CITY OF ALBUQUERQUE

RE: **Kidz Academy**
McMahon and Fineland NW
Grading Plan and Drainage Report
Engineer's Stamp Date 2/20/18 (File: A11D016)

RE: **Kidz Academy
McMahon and Fineland NW
Grading Plan and Drainage Report
Engineer's Stamp Date 2/12/18 (File: A11D016)**

ENGINEER'S SEAL  2/12/18 DAVID SOULE P.E. #14522	KIDZ ACADEMY GRADING AND DRAINAGE PLAN  1606 CENTRAL AVENUE SE SUITE 201 ALBUQUERQUE, NM 87106 (505) 872-0999	DRAWN BY WCWJ DATE 2-12-18 21801-LAYOUT-9-25-17 SHEET # JOB # 21801
---	--	---

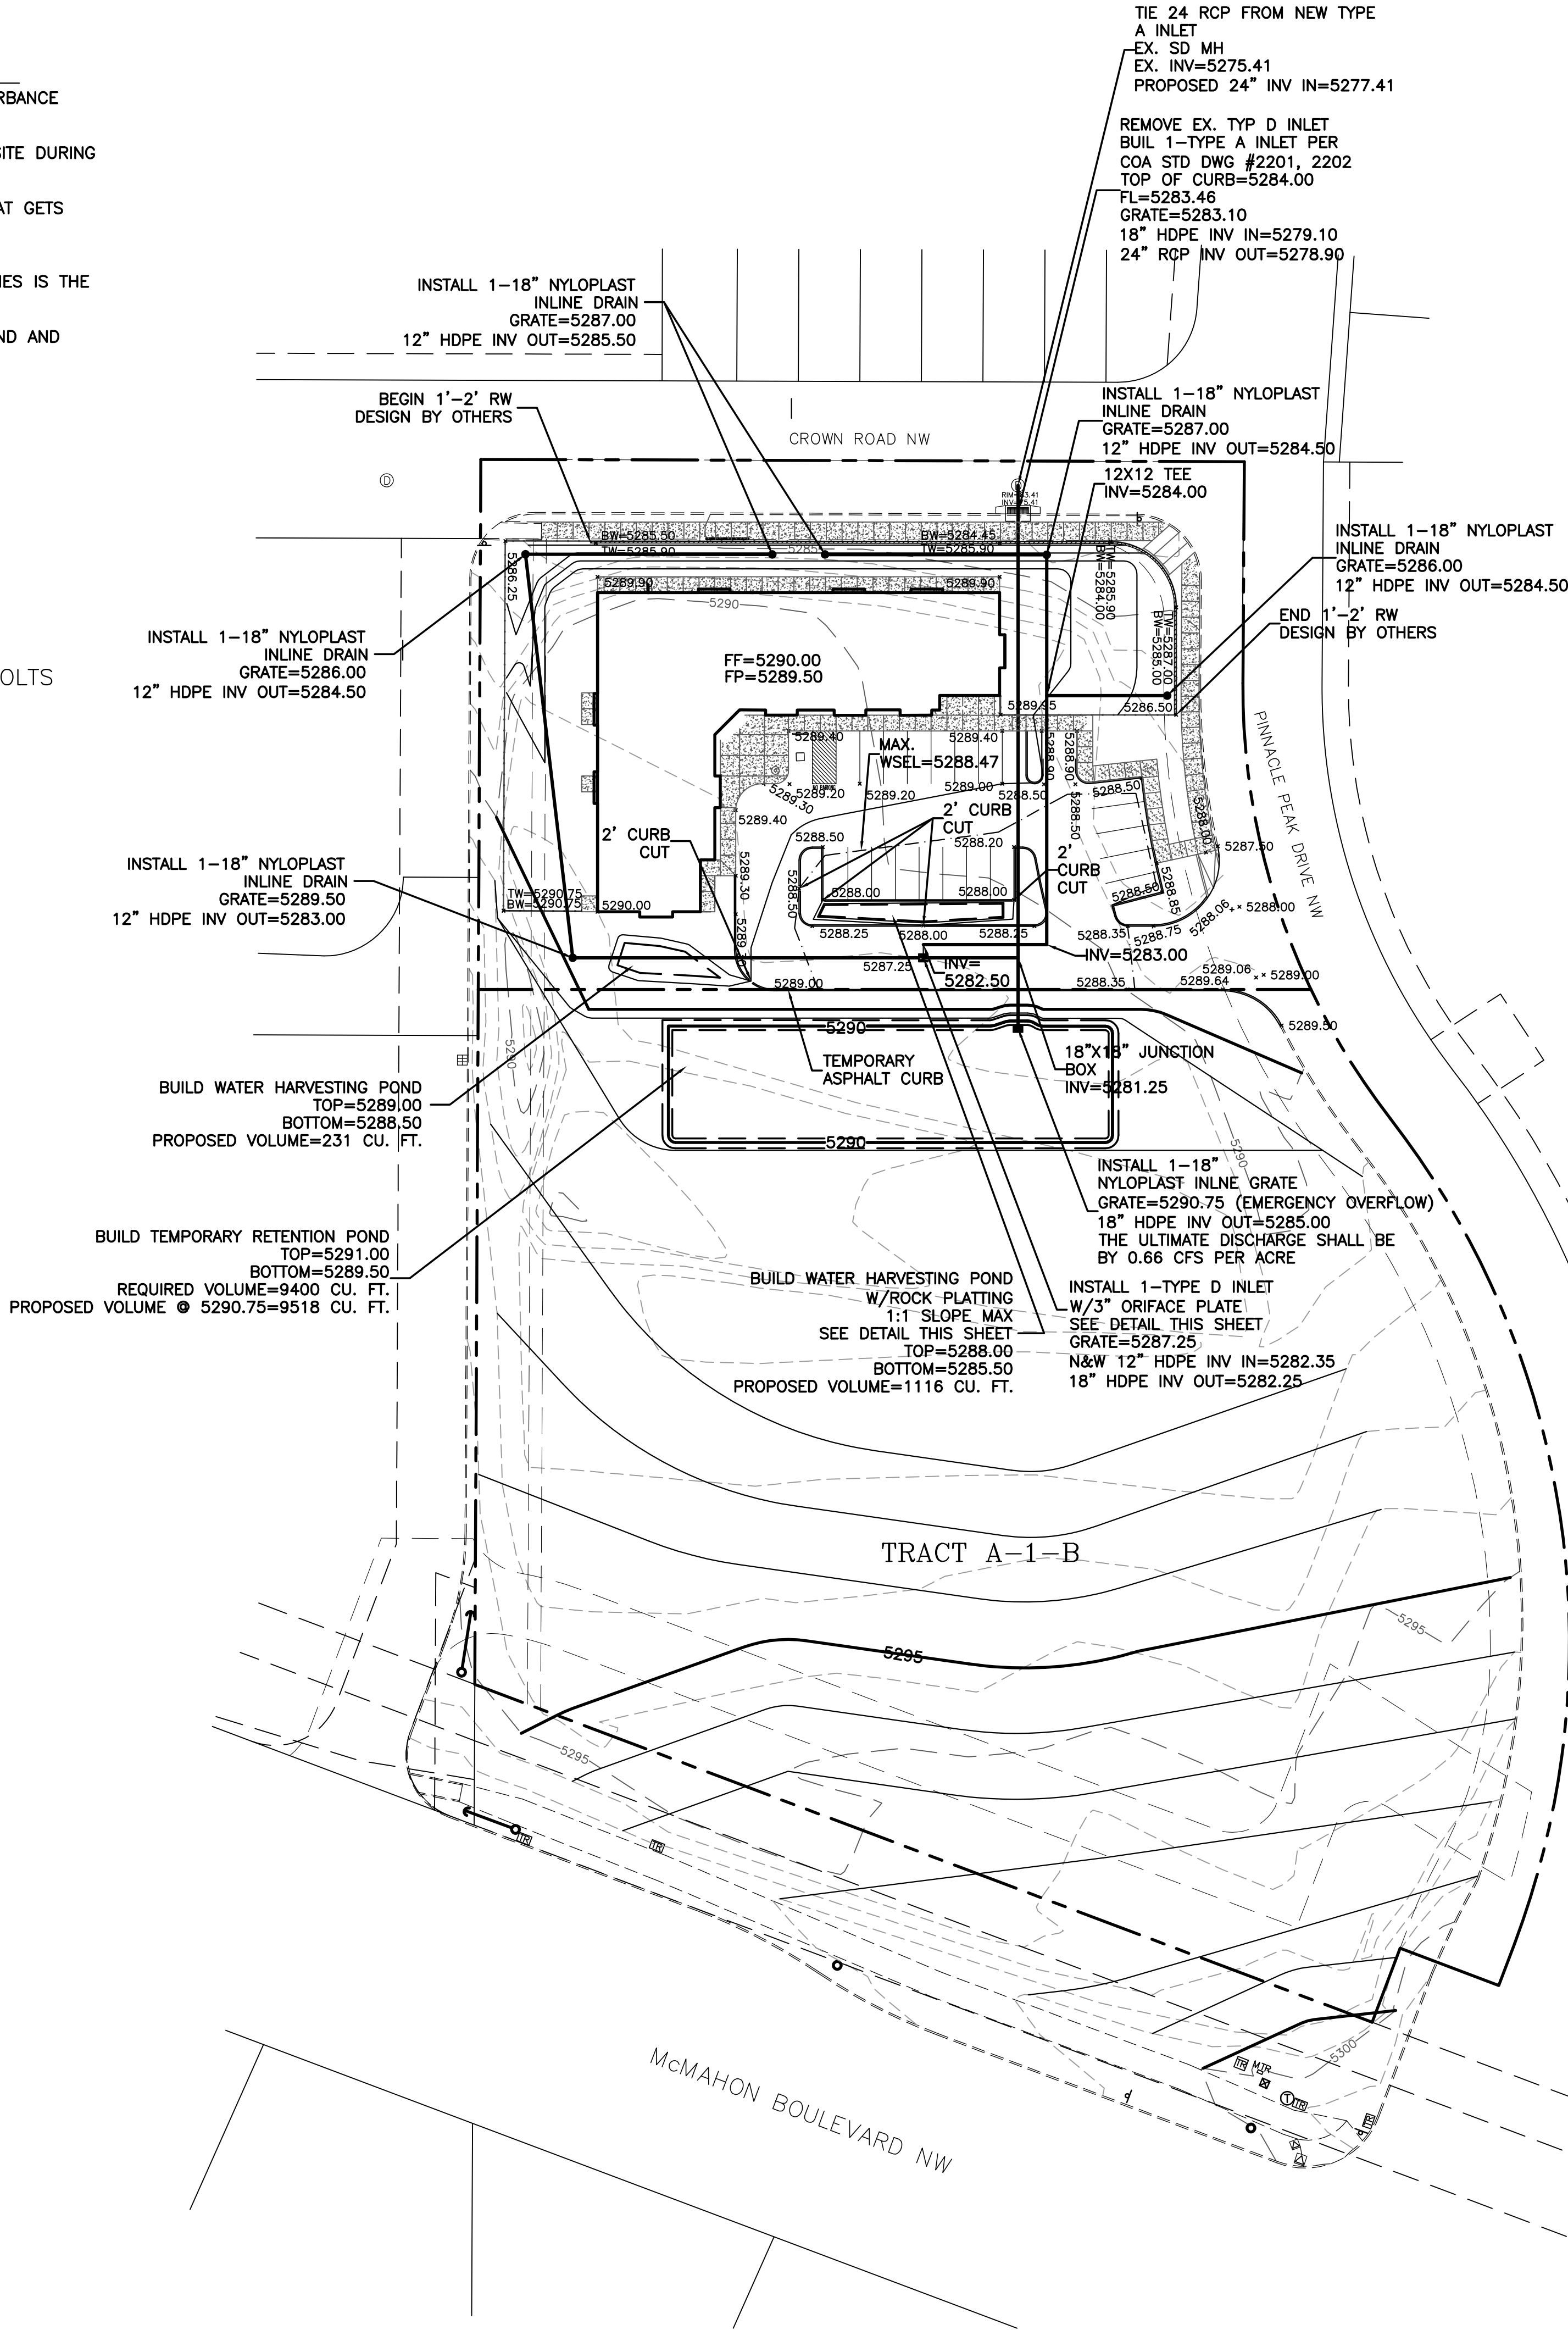
4. The AHYMO model shows the pond as having outflows beginning at elevation 85.52', but on the plan, the inlet grate elevation is at 87.25'. Please clarify the routing. Is this outflow from Basin A bypassing the pond and going right to the orifice plate inlet?
The outflow is the invert of the orifice at 85.50. All basins drain to inlet

5. What is the function of the storm drain w/ inline drains around the building? Previously these were used for routing the roof drains to the orifice plate/inlet near the pond, but now they seem to be just for area drains to capture runoff from Basin A. If so, they do not appear to be placed where they will intercept all flows from Basin A.
The report better explains

6. The small amount of impervious area in Basin A does not appear to be routing through any first flush pond. It appears to either free discharge onto Crown Rd or get routed through the orifice plate/inlet, but not get retained anywhere. If true payment, of Fee-in-Lieu will be required for this impervious area.
INFILTRATION GALLERY PROVIDED FOR BASIN A
